PORTLAND MAINE

December 13, 2011

Re: 29 David Road – 259 A031 - R-3 – disability variance – Permit #2011-12-2899

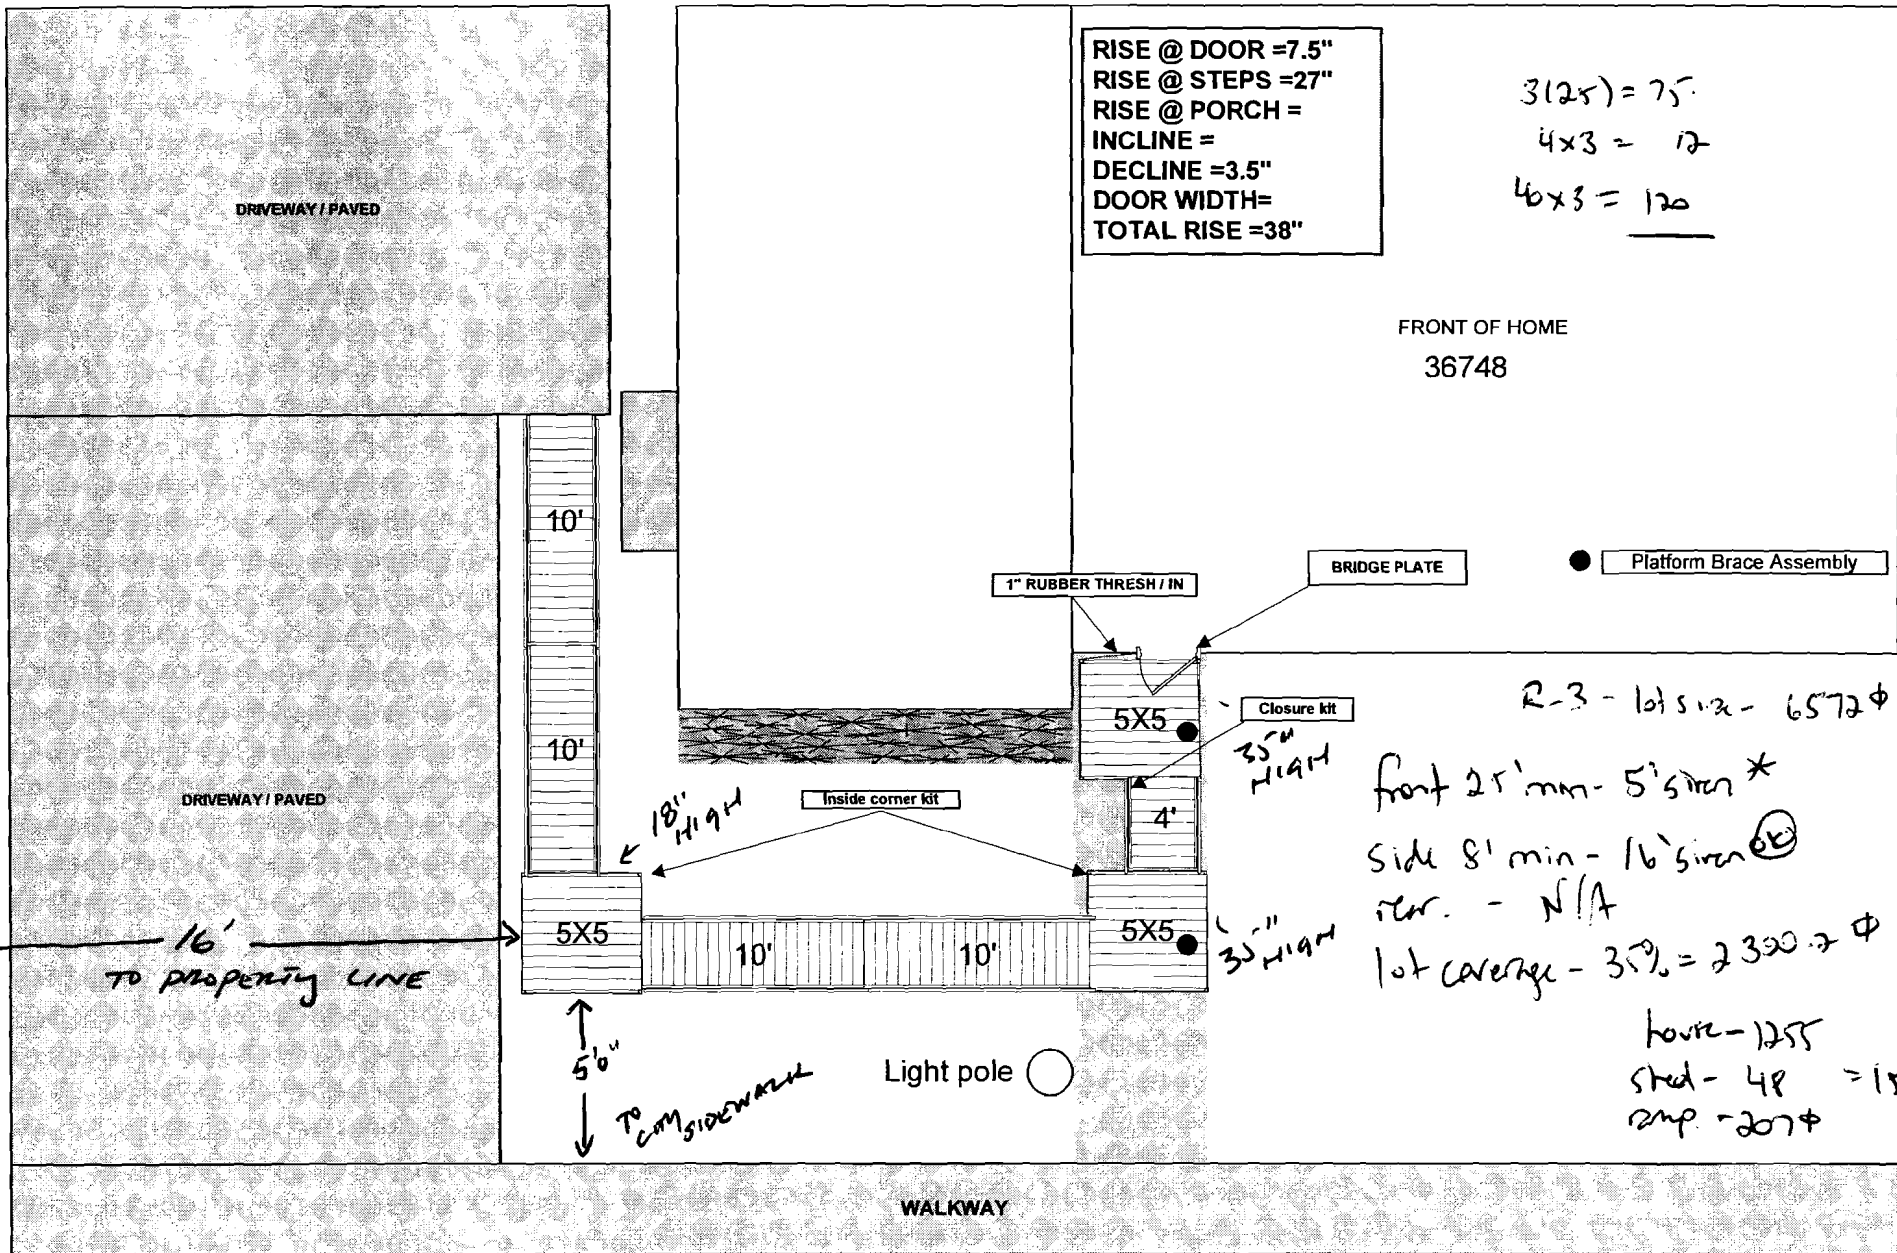
You applied for a permit to build a handicap accessible ramp to access the front door of your property. 29 David Road is located in the R-3 residential zone. The required front yard setback is twenty-five (25) feet [section 14-90(d)(1)]. The plot plan submitted with the permit showed the setback to the proposed ramp as five (5) feet. Since the ramp had to be installed immediately, the permit to build the ramp was issued. Now you need to apply for a disability variance within thirty days of the date the permit was issued, since the ramp does not meet the required front setback of twenty-five feet.
